**Re: Woodlands, School Road, Little Heath**

You have asked me to review the drawings regarding the development that is proposed at the above stated address and to opine on whether the proposed development as set out in Drawing No. 1059-010A, 1059-011A, 1059-012 and 1059-013 would be within Class A of the Town and Country Planning (General Permitted Development) (Amendment) (No. 2) (England) Order 2008 ("the rules").

DRAWN	CHECKED	DATE	SCALE
AAW		JAN 2011	1:100@A1
NUMBER		1059-012	REVISION

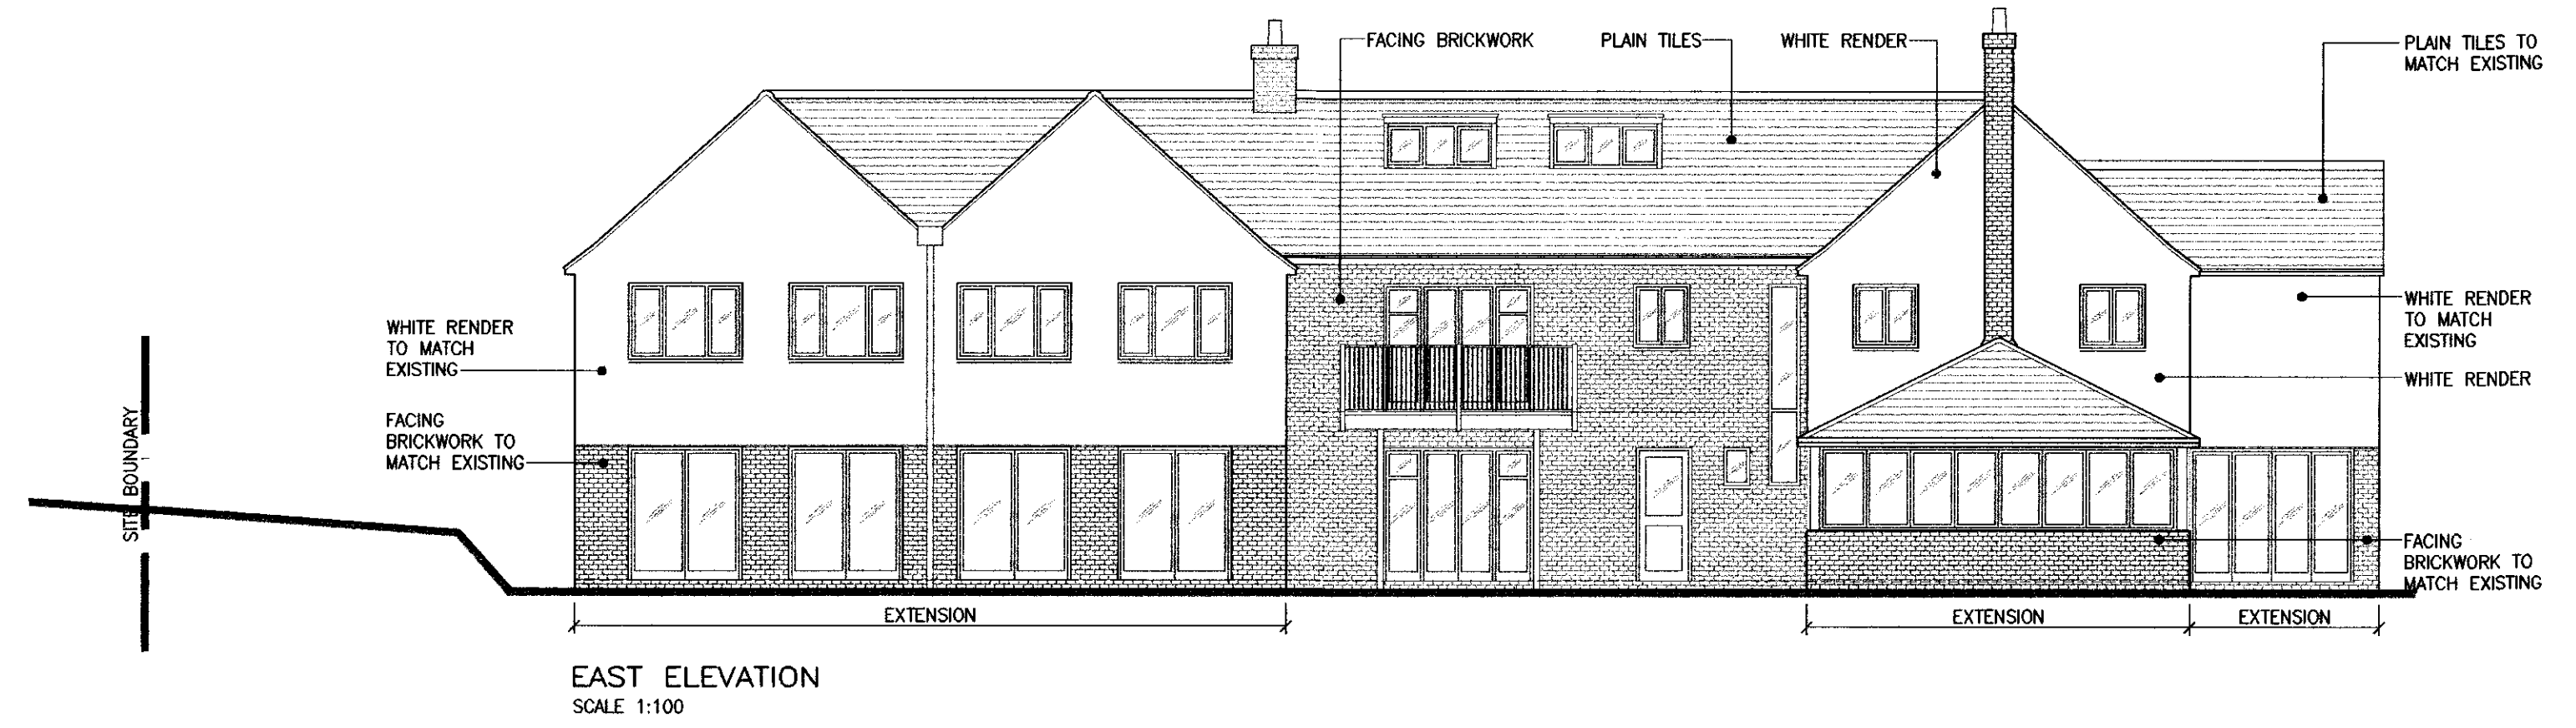
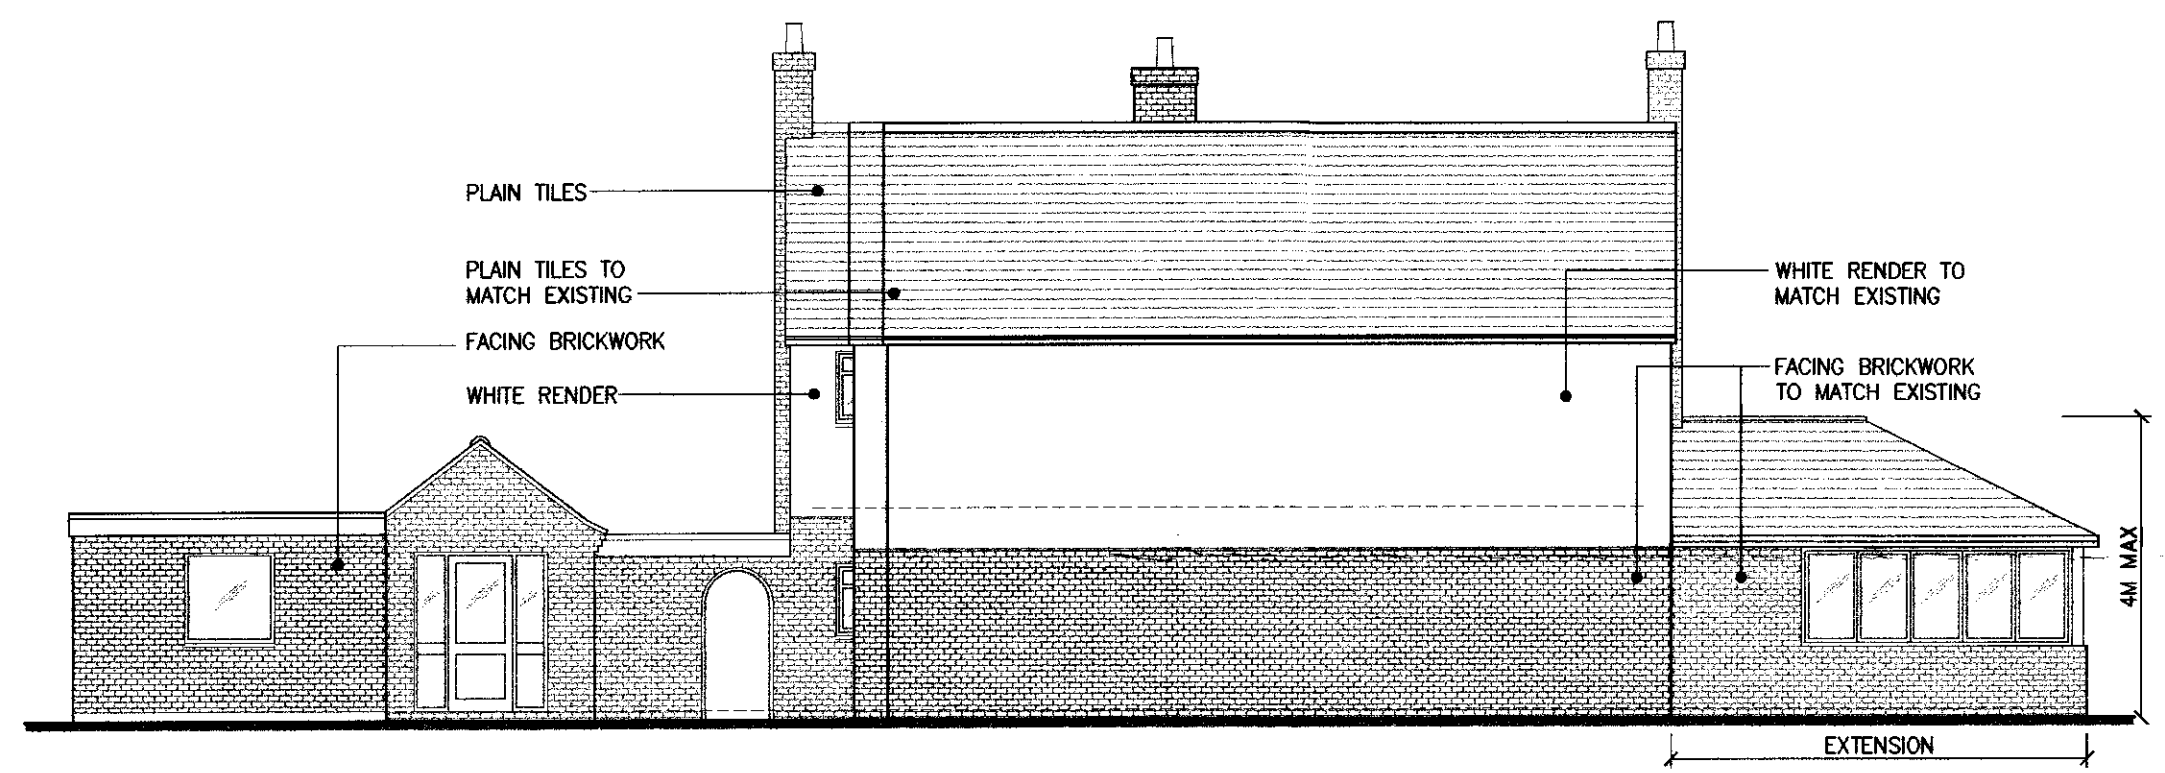
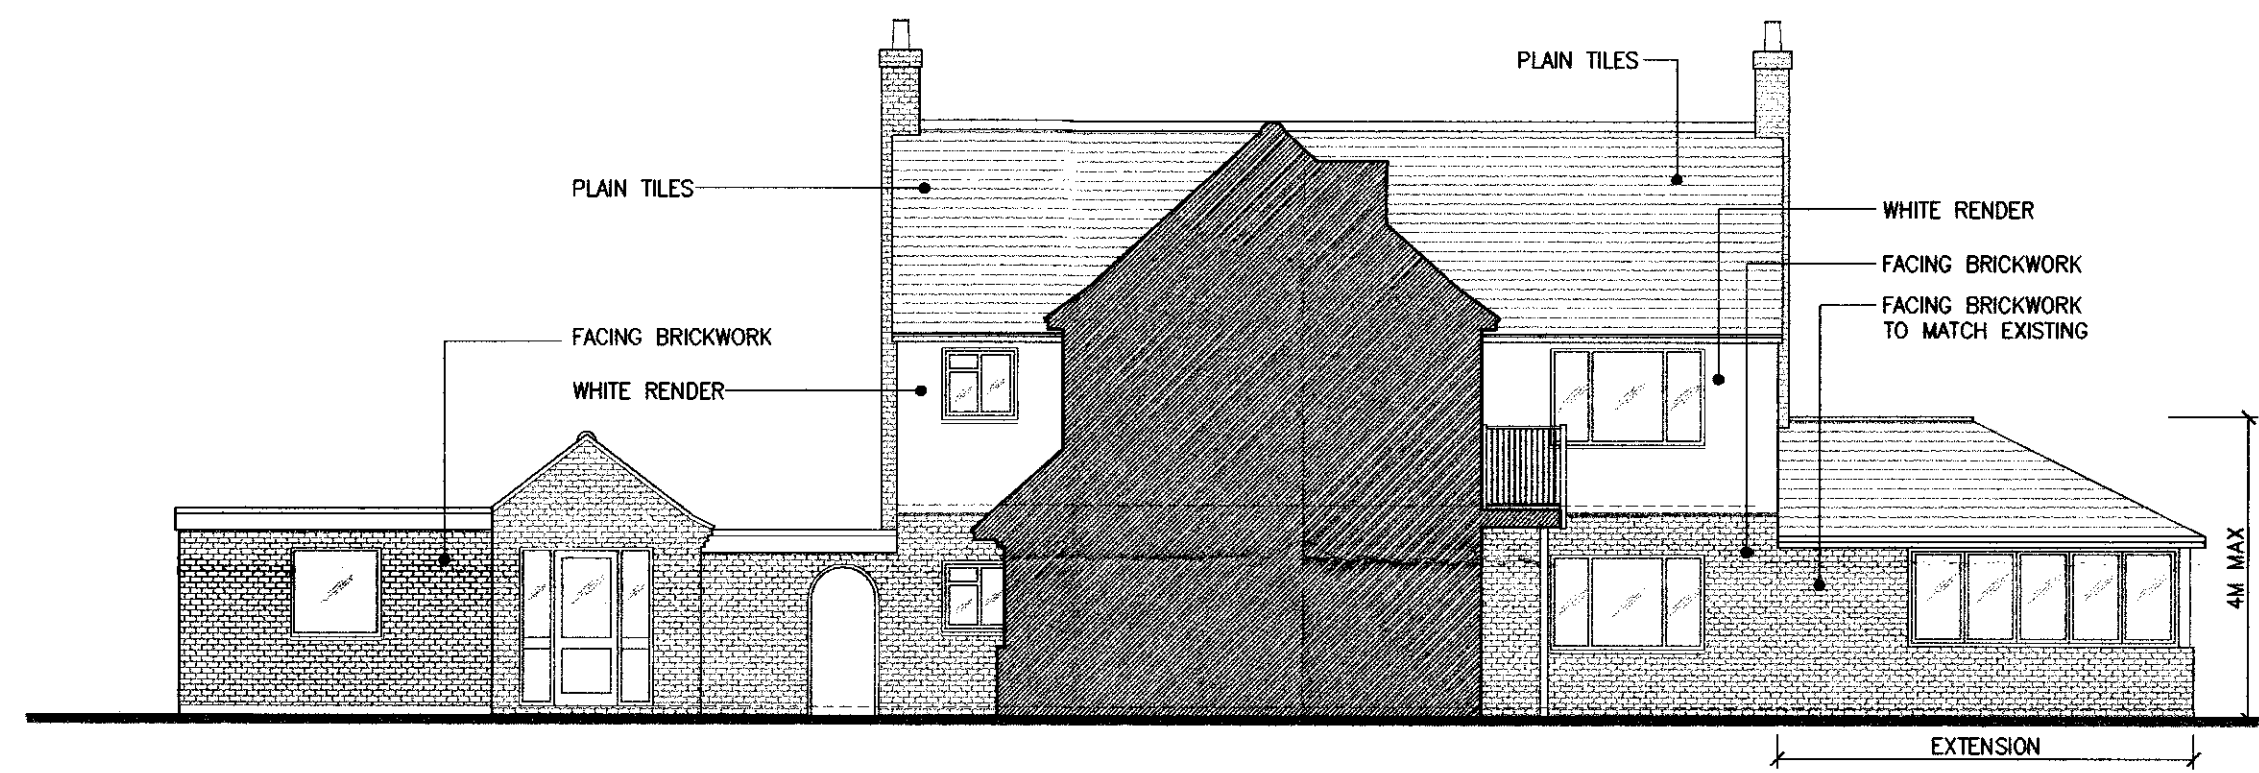
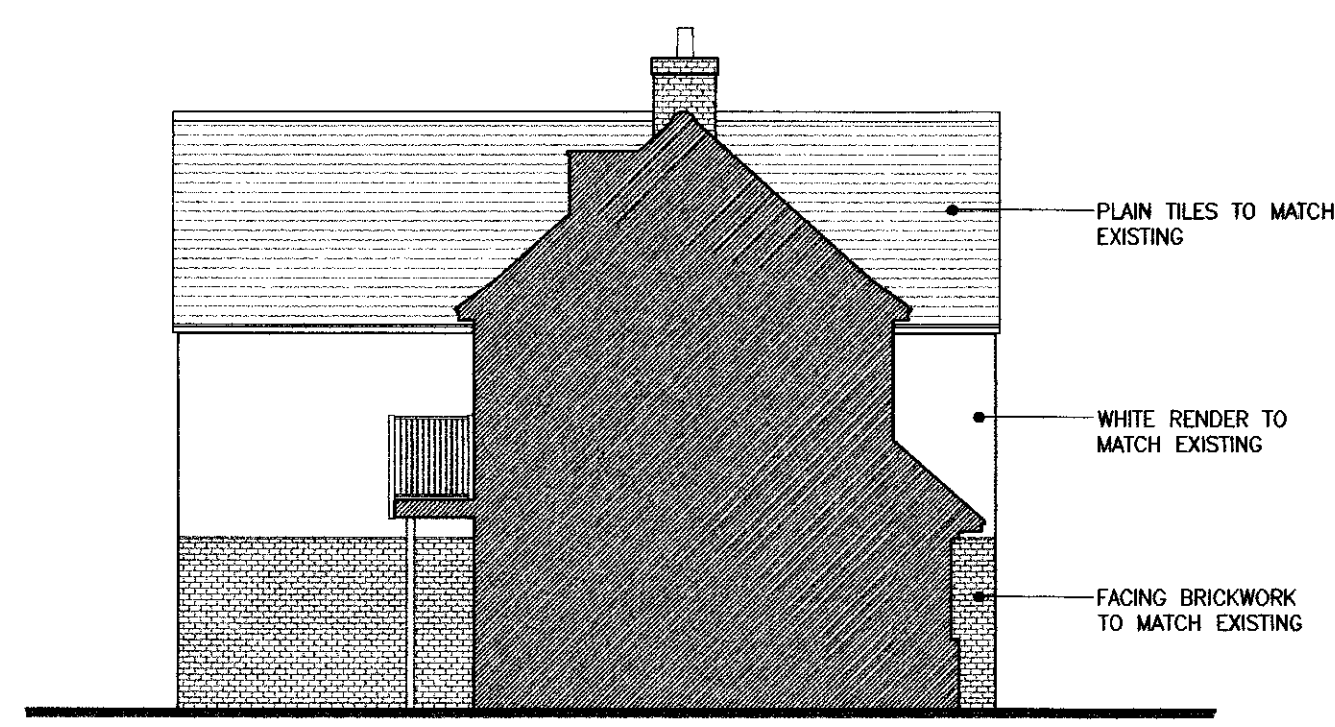
The rear extension as can be seen is a two storey extension. As can clearly be seen from the drawings this does not extend beyond the rear wall by more than three metres and once built there will be at least seven metres between the rear wall of the extension and any boundary wall of the curtilage.

As can be seen from the drawings the side extension will not exceed four metres in height and will be single storey. The width of the original dwellinghouse was 11.66 metres and the proposed side extension will measure at 5.5 metres, which is therefore less than half the width of the original dwellinghouse.

DRAWN / CHECKED	NUMBER	DATE	SCALE	REVISION
AAW	1059-013	FEB 2010	1:100@A3

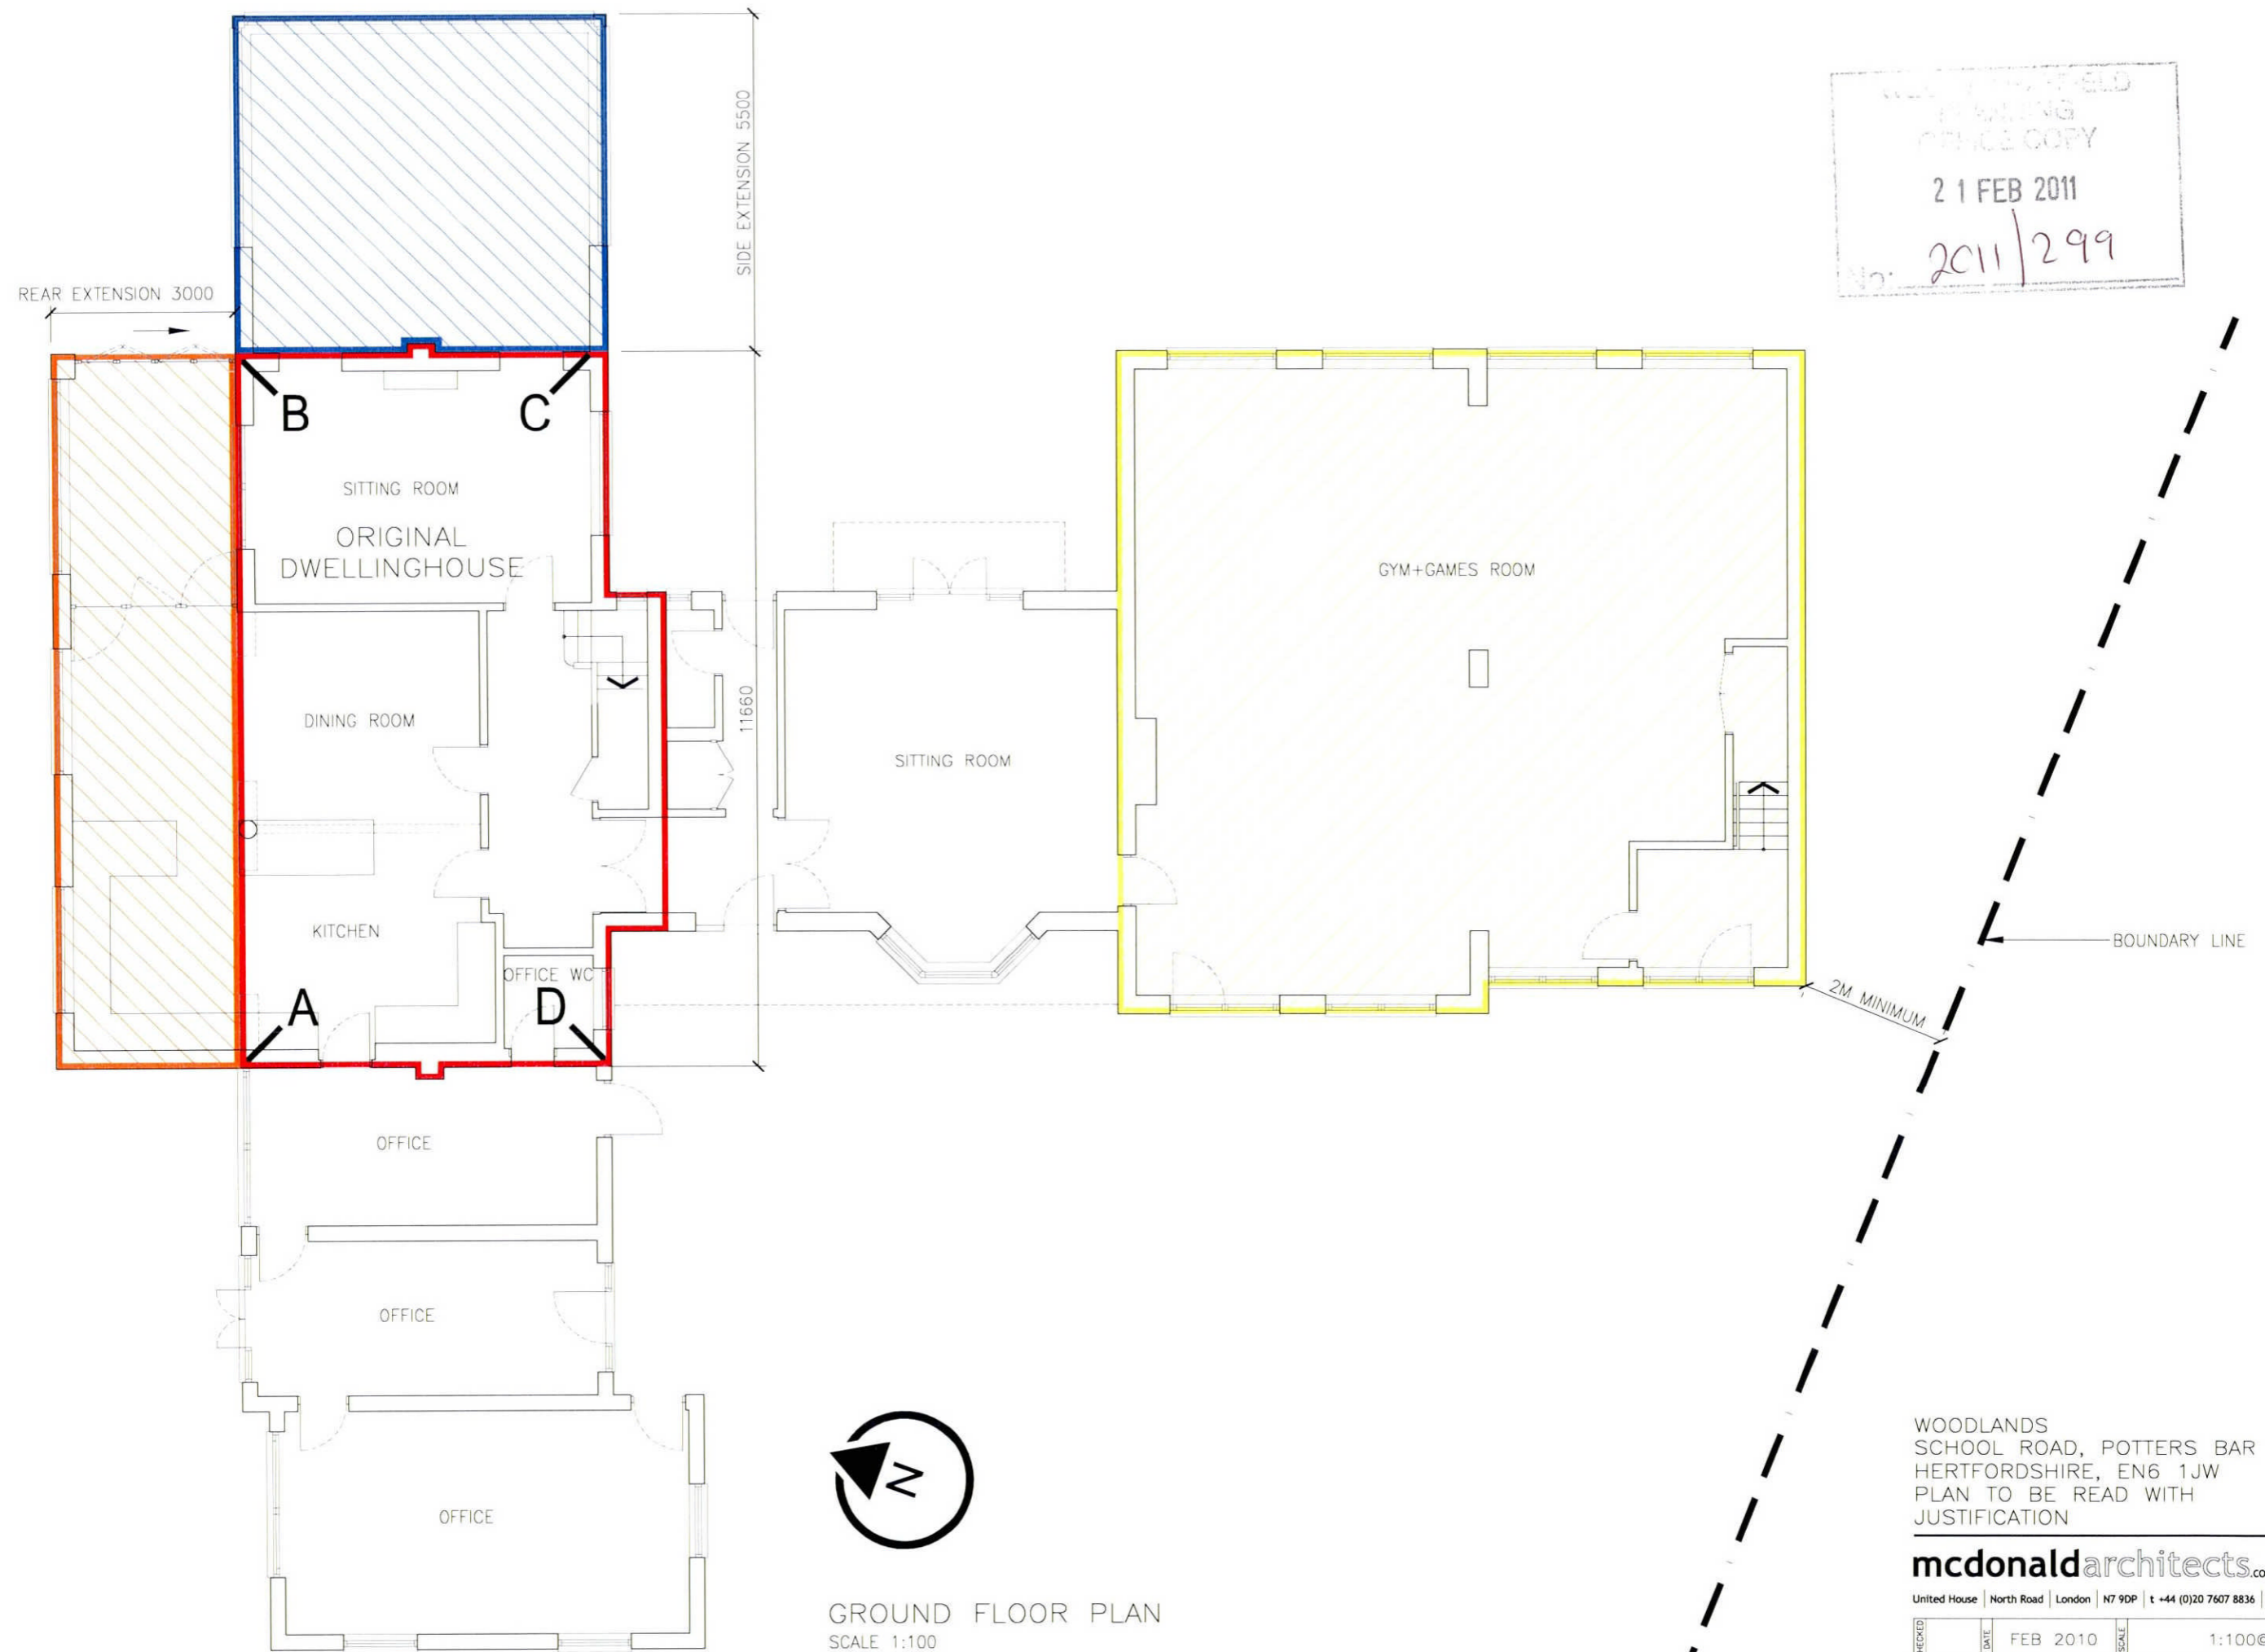
Outlined in red on Drawing No. 1059-013 is the original dwelling. This is then marked with points, A, B, C and D. Original means a building as it existed on 1 July 1948 where it was built before that date, and as it was built when built after that date. Between points C and D is what would have constituted the principal elevation of the original house. This would have constituted the front of the house, with the property's main architectural features, such as bay windows and the main entrance to the house. Usually the front of the house will be the principal elevation.

This is the extension which extends beyond the front elevation of the original dwellinghouse beyond points C and D. This has been outlined and hatched in yellow at Drawing No. 1059-013.

It is my opinion that due to the distance between the property and School Road, that the property does not front a highway. There is intervening land not owned by the client between the property and the highway. Because this is the case the proposed extension hatched in yellow would be permitted subject to the following:-

The height of this extension will not exceed the levels provided for in (i) and (ii) and although the height of this part of the development would exceed three metres, the drawings show that there would be a minimum of two metres between the enlarged part and the boundary of the curtilage.

The rear extension is that which extends beyond the rear wall of the original property, beyond the wall marked between points A and B. This extension has been outlined and hatched in orange.

The side extension to the property is that which extends beyond the side wall between points B and C and is outlined and hatched in blue on Drawing No. 1059-013.
